Appeal Decision

Appeal Ref: APP/R5510/W/21/3271454

Pump Lane, Hayes, London, UB3 3LP

- The appeal is made under section 78 of the Town and Country Planning Act 1990 against a refusal to grant approval required under Schedule 2, Part 16, Class A, of the Town and Country Planning (General Permitted Development) (England) Order 2015 (as amended).
 - The appeal is made by Hutchison 3G UK Ltd against the decision of London Borough of Hillingdon.
 - The application Ref 76044/APP/2020/3862, dated 18 November 2020, was refused by notice dated 12 March 2021.
 - The development proposed is telecommunications installation: Proposed 15.0m Phase 8 Monopole C/W wrapround Cabinet at base and associated ancillary works.
-

Title: 210 PROPOSED H3G SITE PLAN

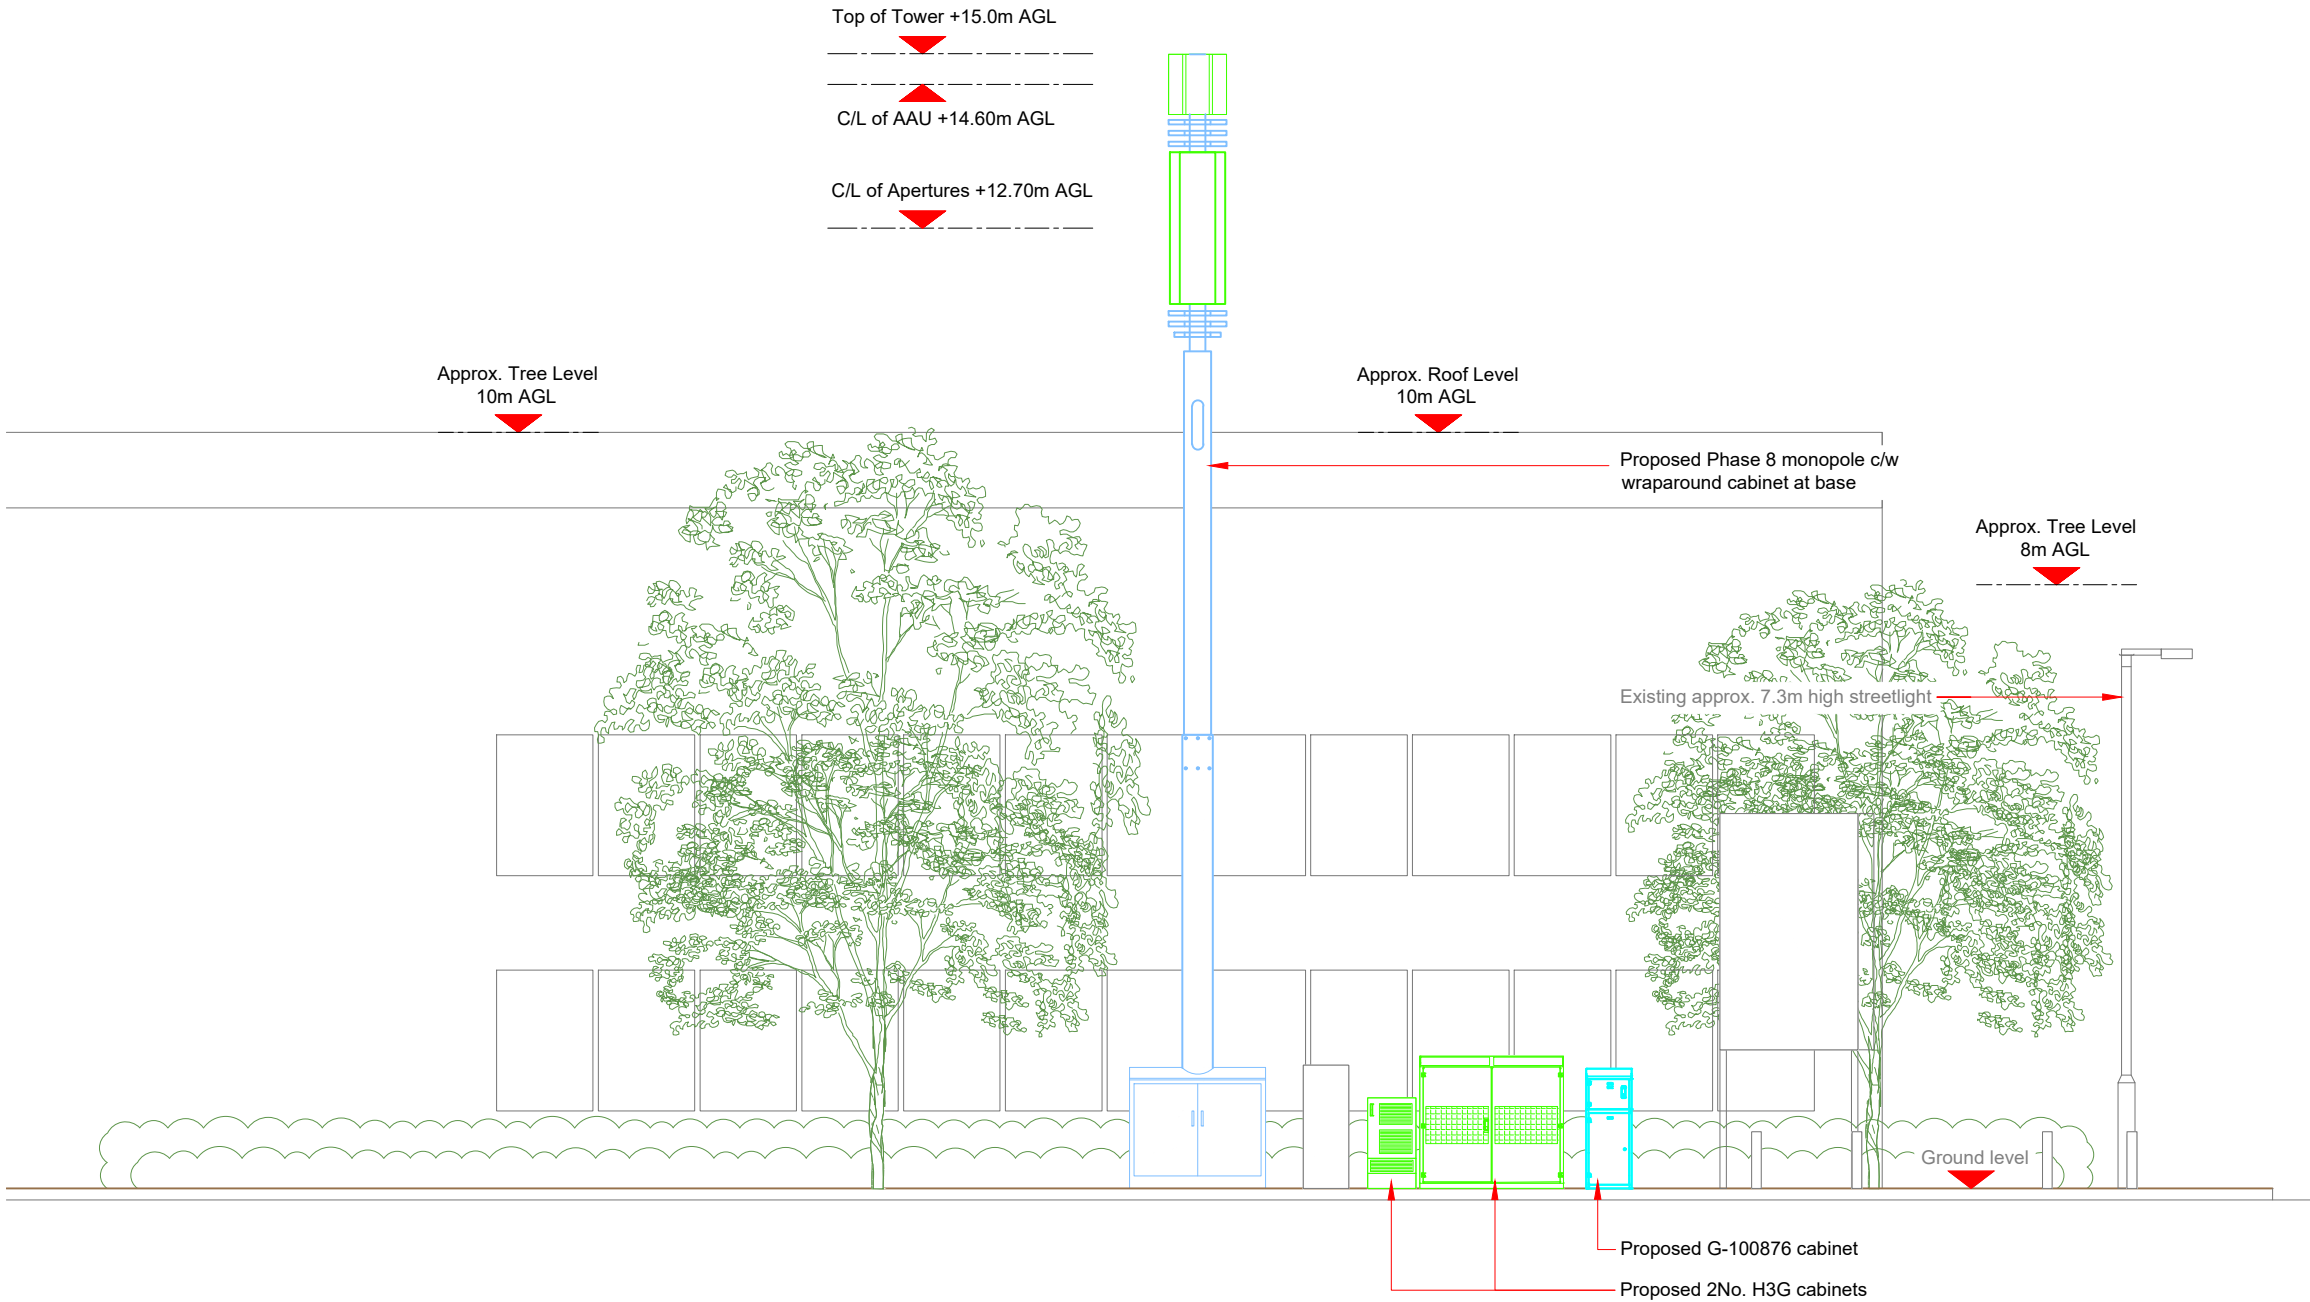
8. There is a mature tree in very close proximity to the proposed development which currently, as with most nearby trees, has a large canopy. The Arboricultural Impact Assessment (AIA) indicates the tree to be of moderate quality, in a good condition and of middle age with a long remaining contribution.

9. There may be better rooting space in the soft verge. Nonetheless, a large part of the monopole and base cabinet would require excavation within the root protection area of this tree that is already constrained by the surrounding hard surfaces and utilities. The AIA outlines that pruning would be needed to accommodate the proposal to give clearance for lifting operations and installation of the mast without any obstruction by branches. While branch growth over the cabinets is possible, the AIA also suggests that future pruning may be required as the tree increases in size. These works would truncate the canopy of the tree and have potential implications for roots.

10. Given the limited separation between the tree and the development, uncertainty over the effect of the groundworks on the root system along with initial and longer-term pruning, there would be potential for the tree to be damaged and ultimately lost.

11. The loss or distorting of the tree would erode the aesthetically pleasing influence it has on the streetscene. This would result in more of the pole and cabinets being exposed and prominent in both long and short distance views along this relatively straight part of Pump Lane. It would create more open views of the existing built form that the tree in its current form helps to screen.

12. Therefore, for the reasons set out above, due to its siting and appearance, the proposed development would have a significant harmful effect upon the character and appearance of the area. Therefore, insofar as they are a material consideration, the scheme would fail to accord with the design aims of Policy BE1 of the Hillingdon Local Plan: Part One - Strategic Policies and Policies DMHB11, DMHB12, DMHB14 and DMHB 21 of the adopted Hillingdon Local Plan: Part Two - Development Management Policies.

Title: 260 PROPOSED H3G ELEVATION

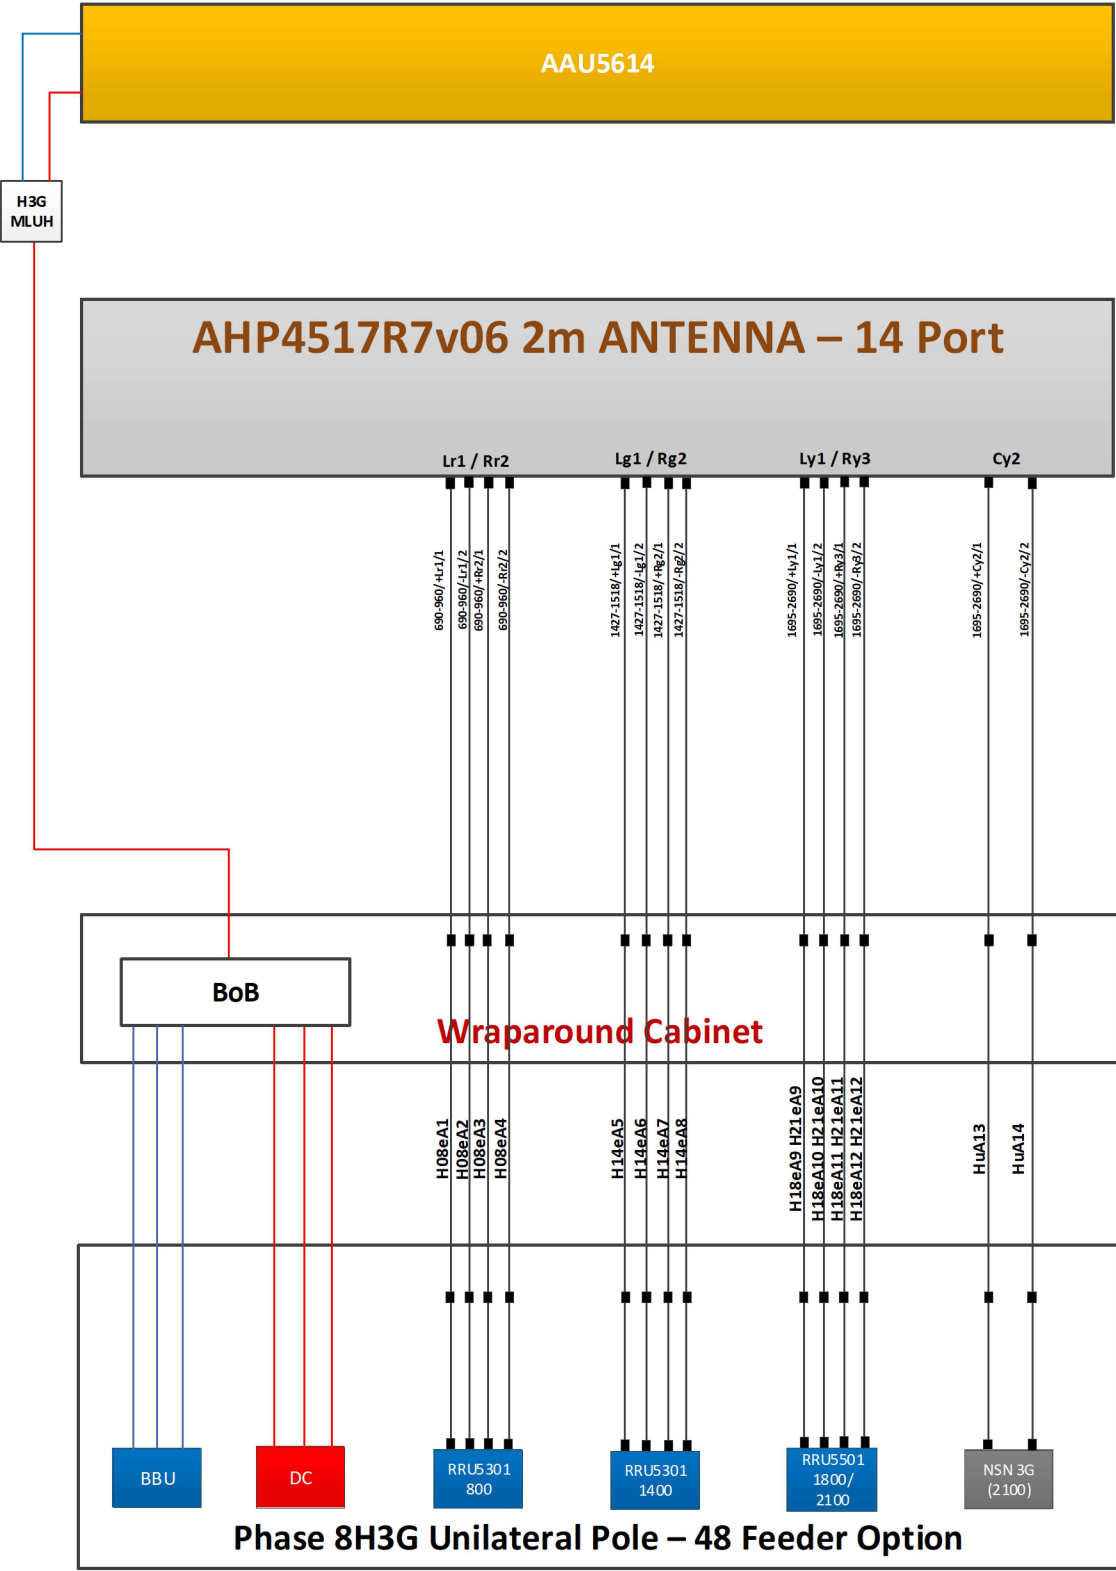
7. There are vertical features such as street lighting within and close to the footway. There are also a number of bollards, cabinets and other low level functional features within the footway near the site. As such, while the pole would be taller, and cabinets larger and more closely grouped, than many of these existing features, the presence of manmade utilitarian features is not unusual. However, such features are predominantly screened, other than in close range views, by the mature street trees and other vegetation that contribute positively to the character and appearance of the street.
